Application for a non-material amendment following a grant of planning permission.

Erection of Detached House with Detached Garage	
Reference number:	H19-0083-15
Date of decision	06/02/2015

Enlargement of proposed garage to move the staircase internally and provide additional welfare facilities for staff, including a shower and utility space.
Addition of a sun lounge to the rear of the dwelling complete with additional roof lights.

P1	First Issue	08/09/18
Revision	Notes	Date
PROJECT: Proposed Alterations Jessamine Coronation Avenue Throckenholt SPALDING PE12 0QT		
DRAWING: Revised Garage Plans & Elevations		
DRAWN: DPF	DATE: Sep 18	
STATUS: PLANNING	SCALE: As Shown	
DRAWING NUMBER: 1022-AR-2003-P1	PAPER: A1

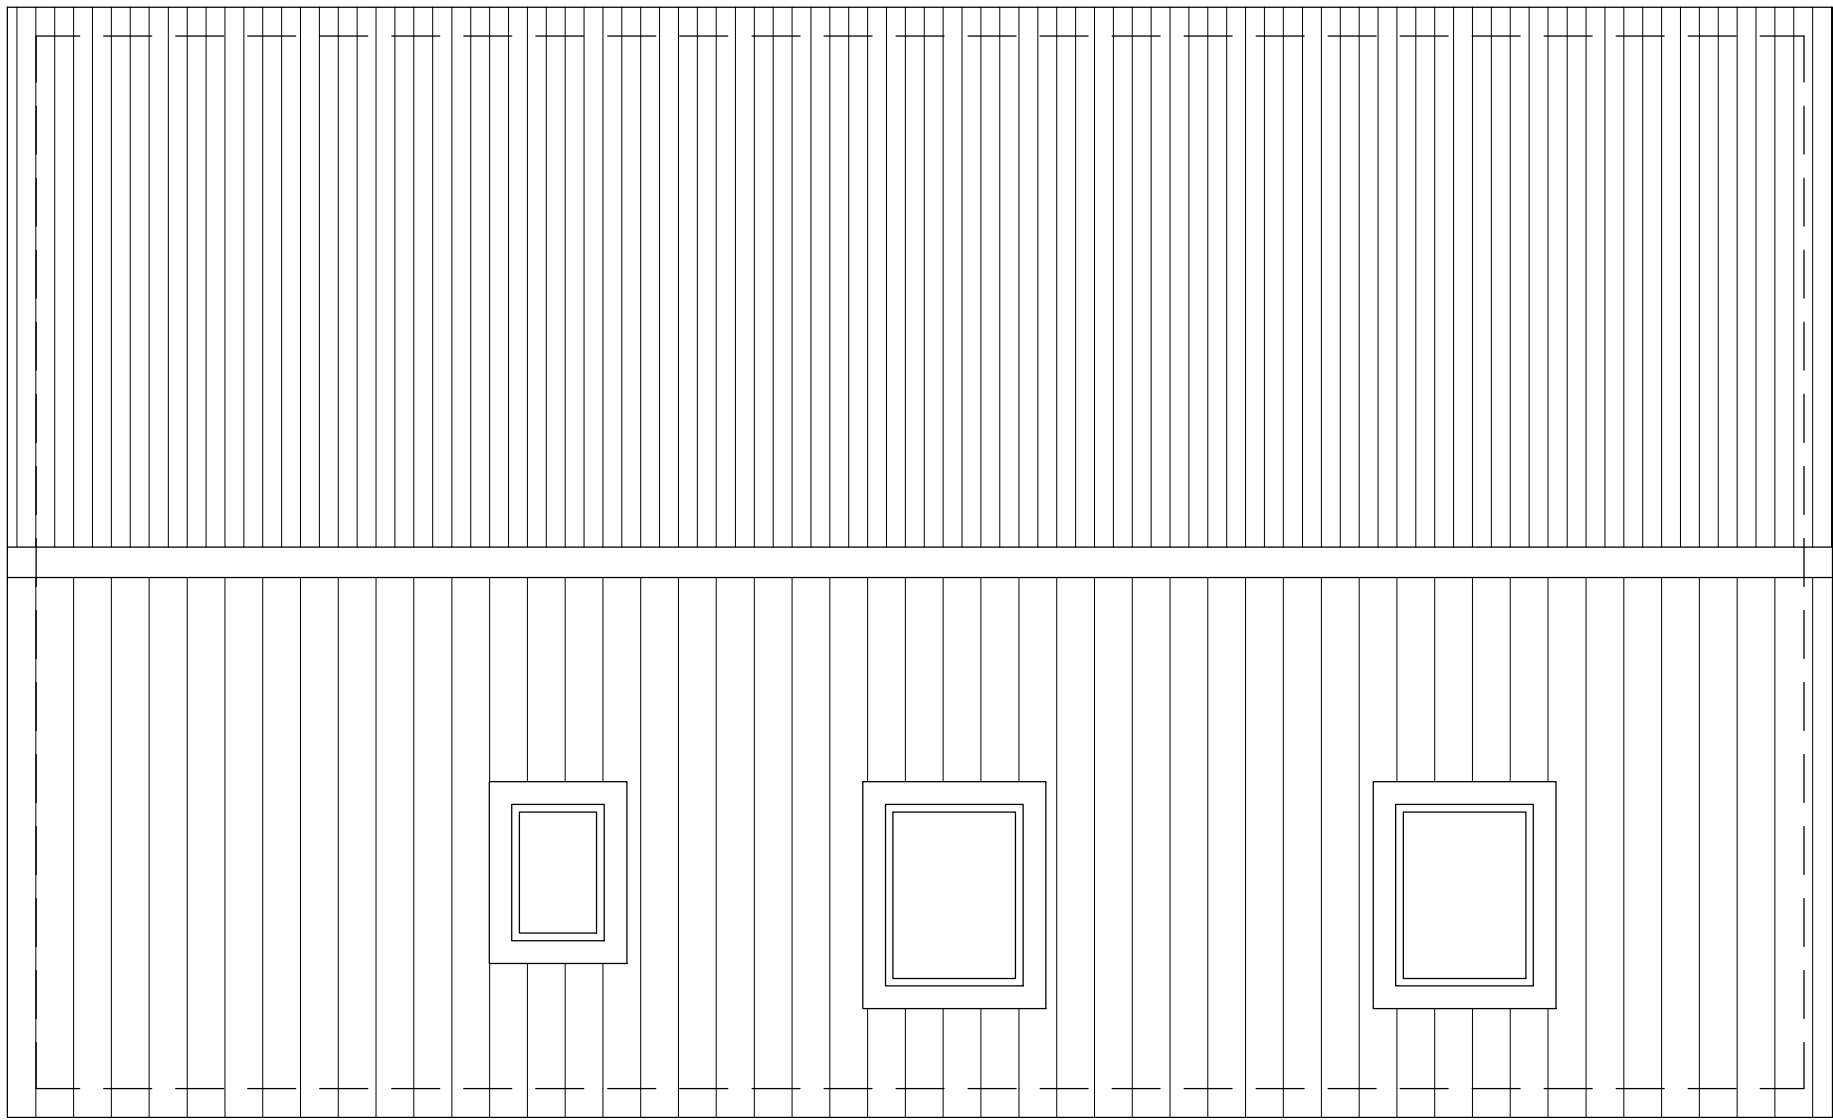
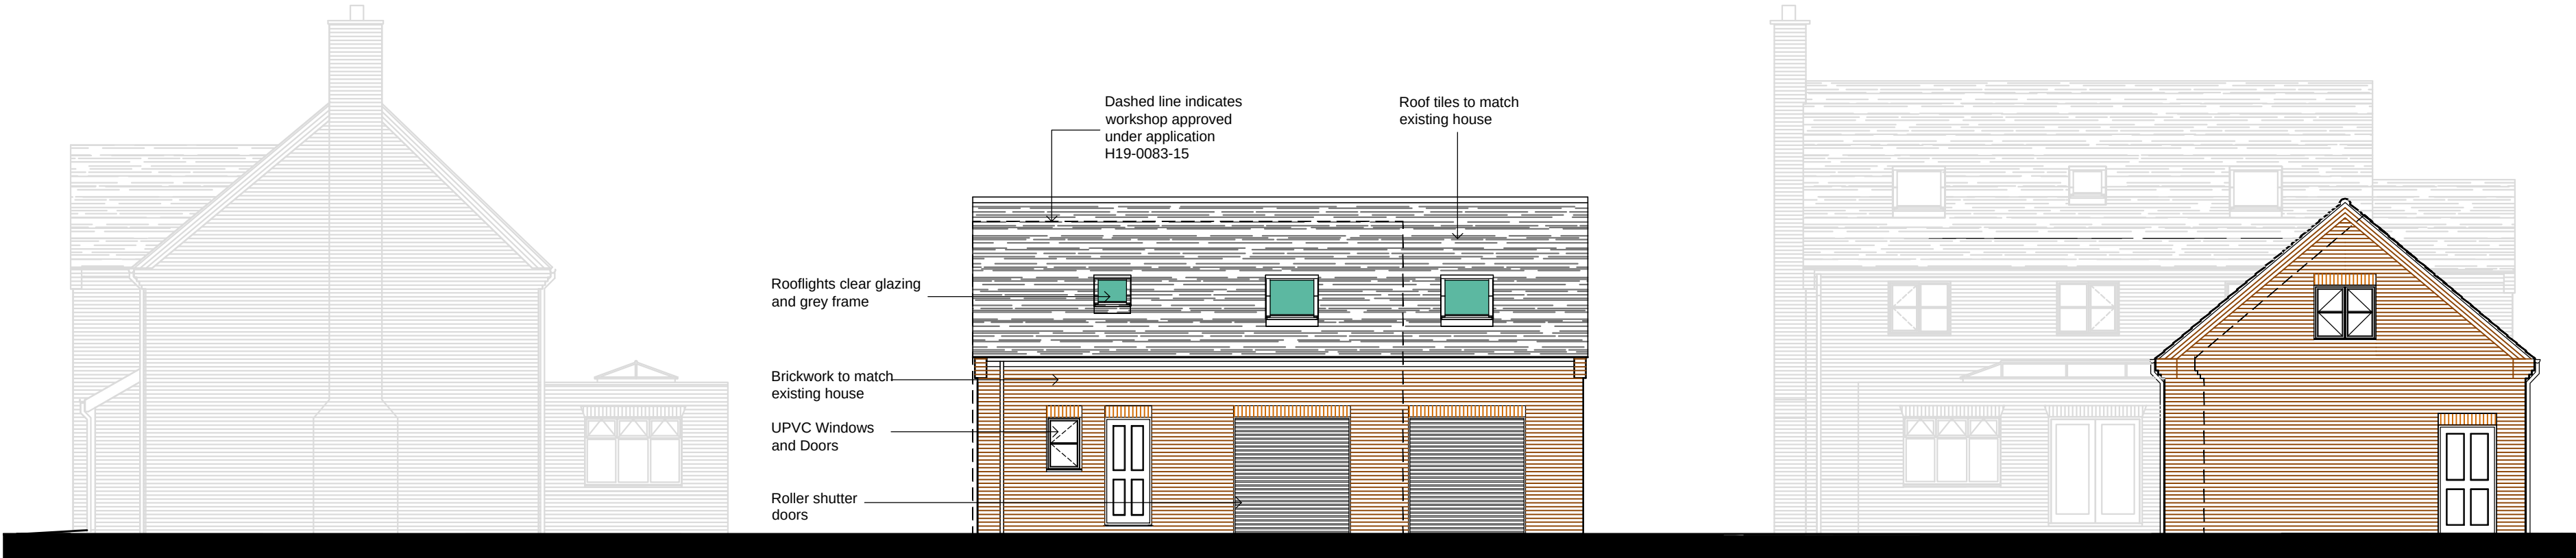
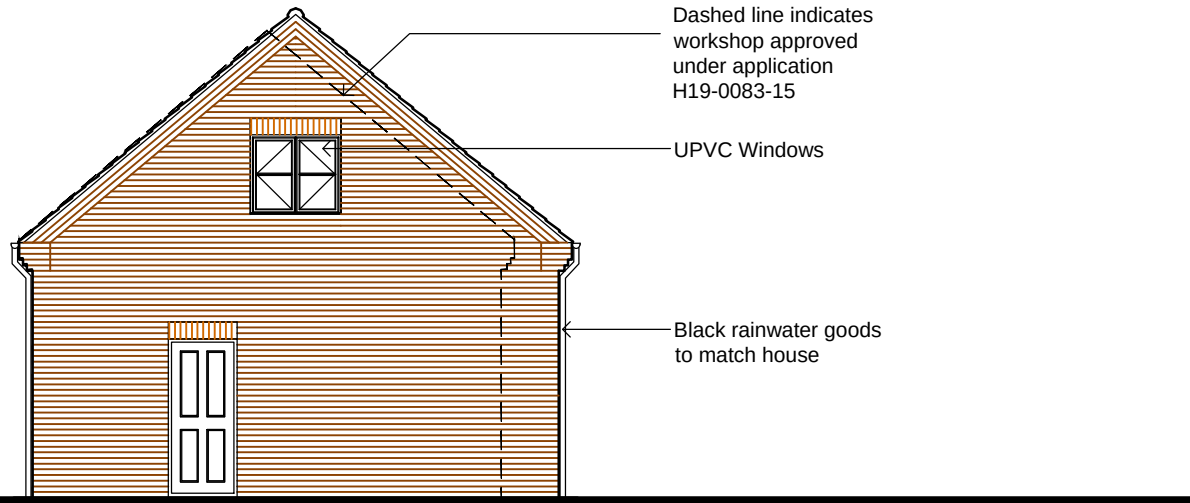
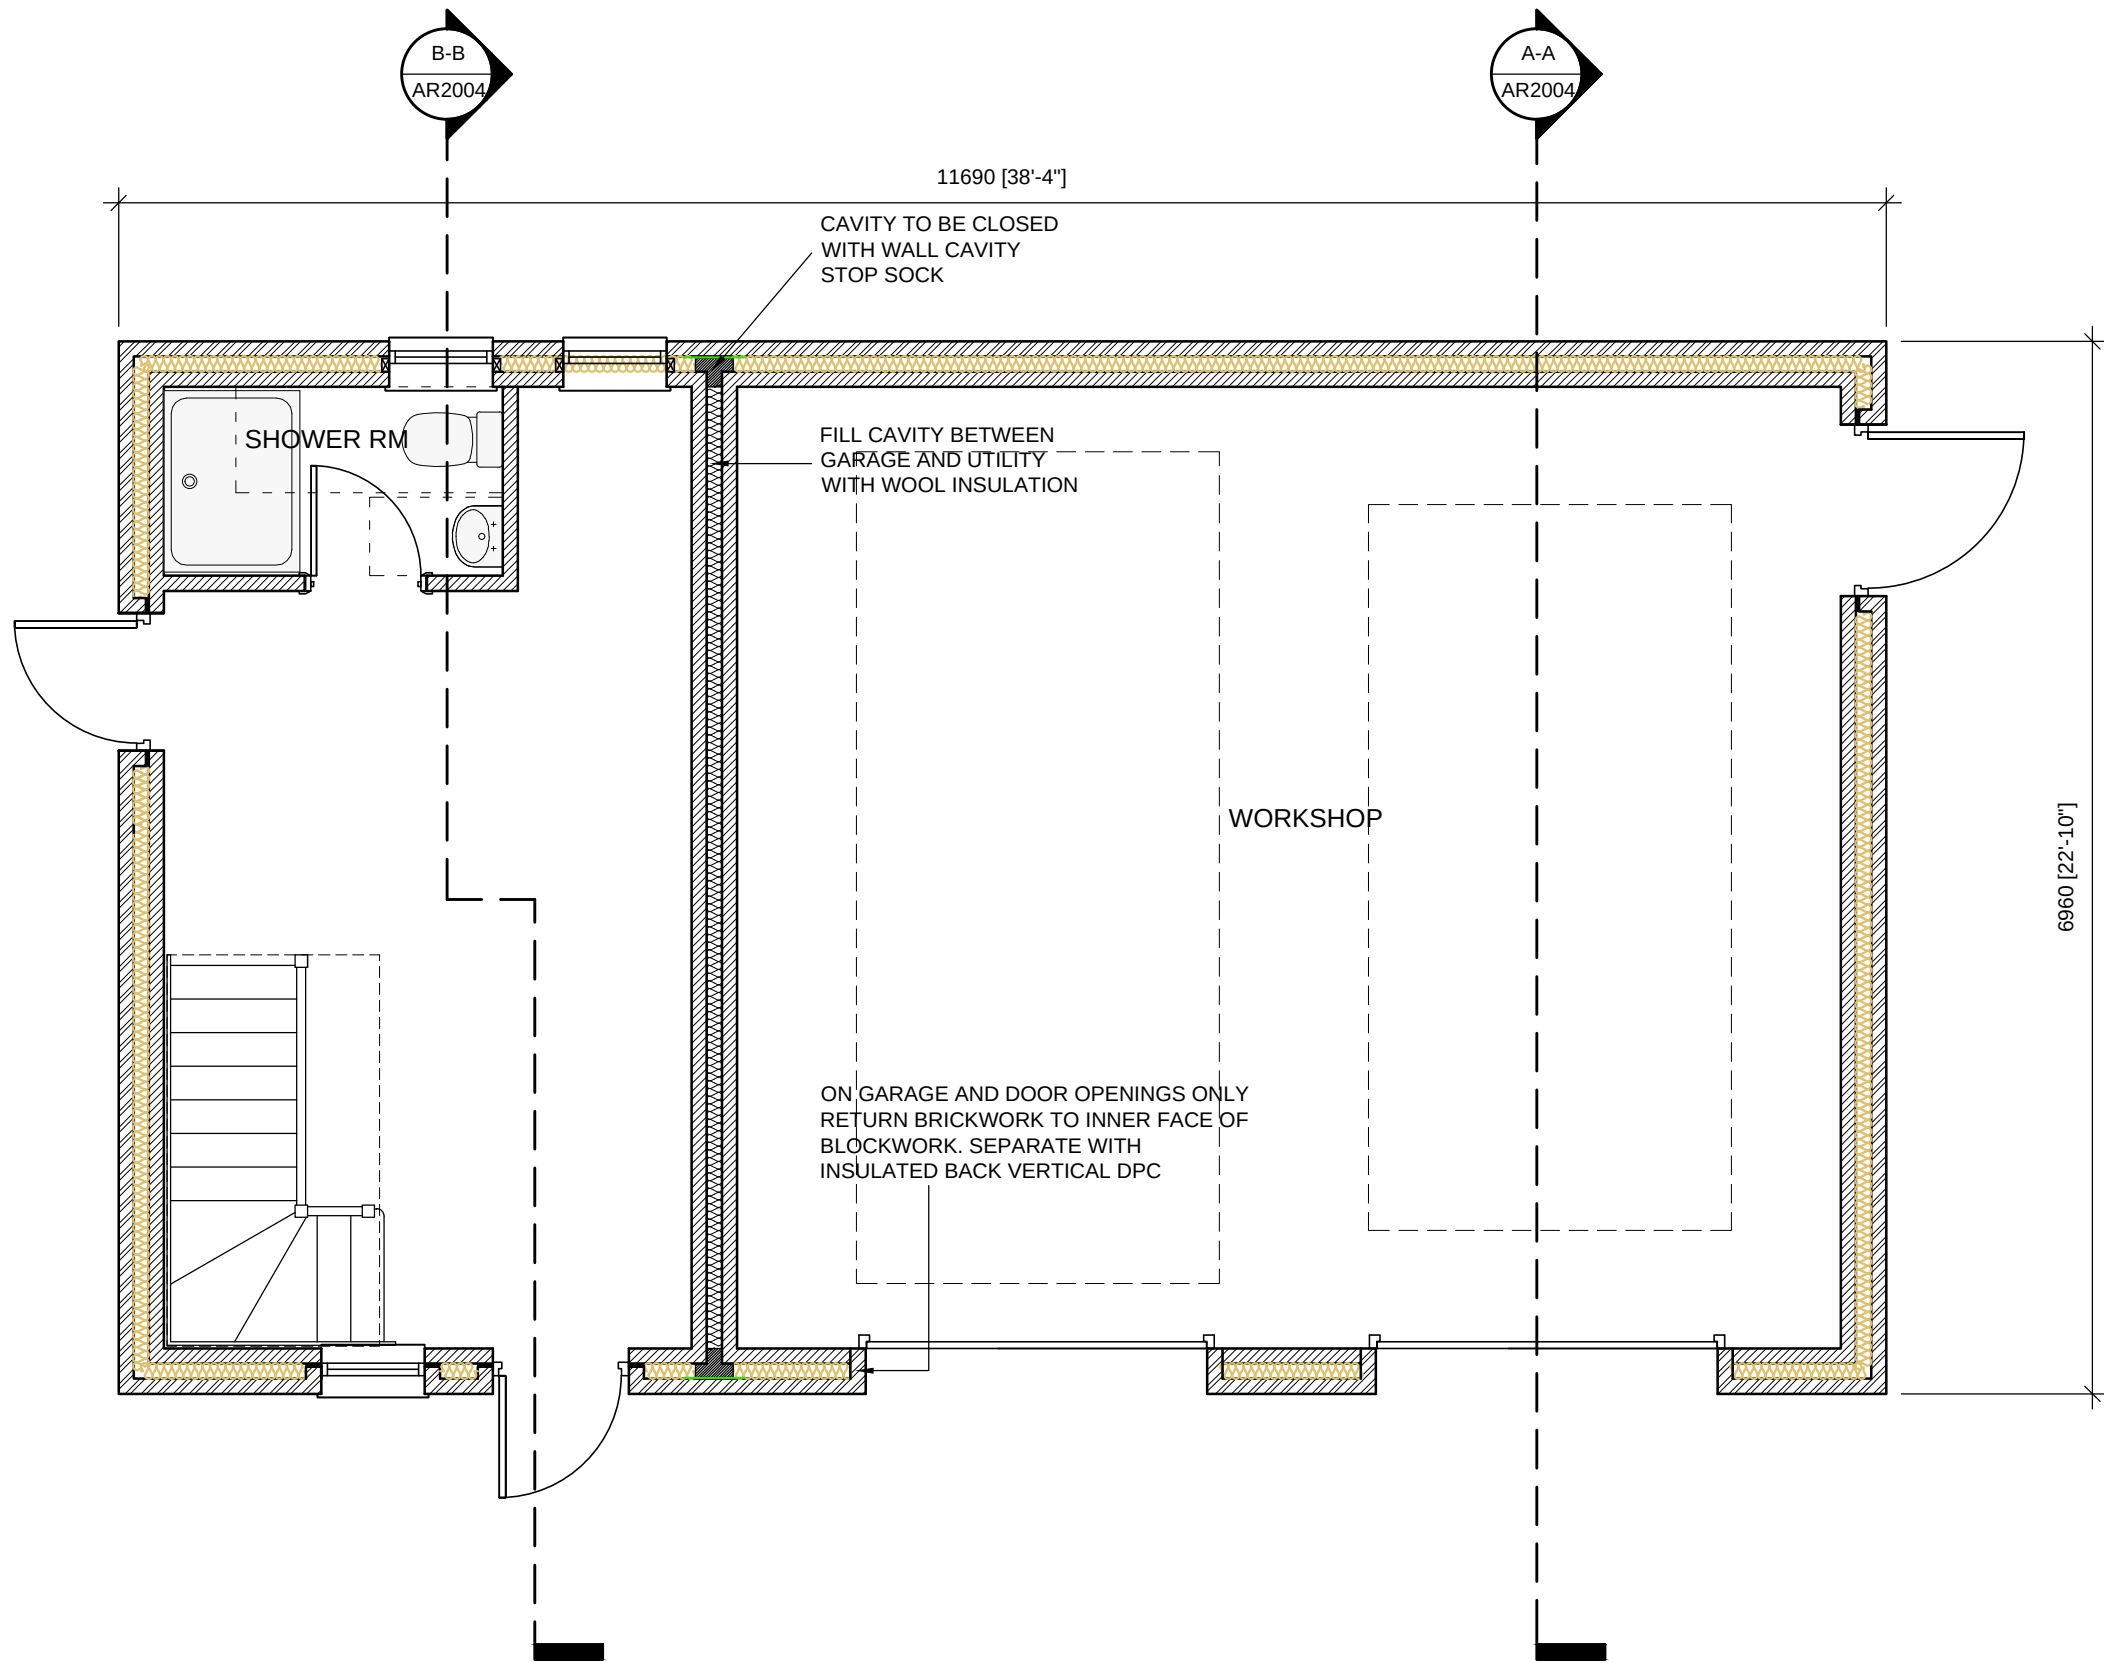
Due to the expansion of the business and additional workload a large breakroom is required together with additional parts storage and welfare facilities.
The sun lounge has been added to enhance the ground floor space. Roof lights have been added to naturally light the internal staircase and rooms.
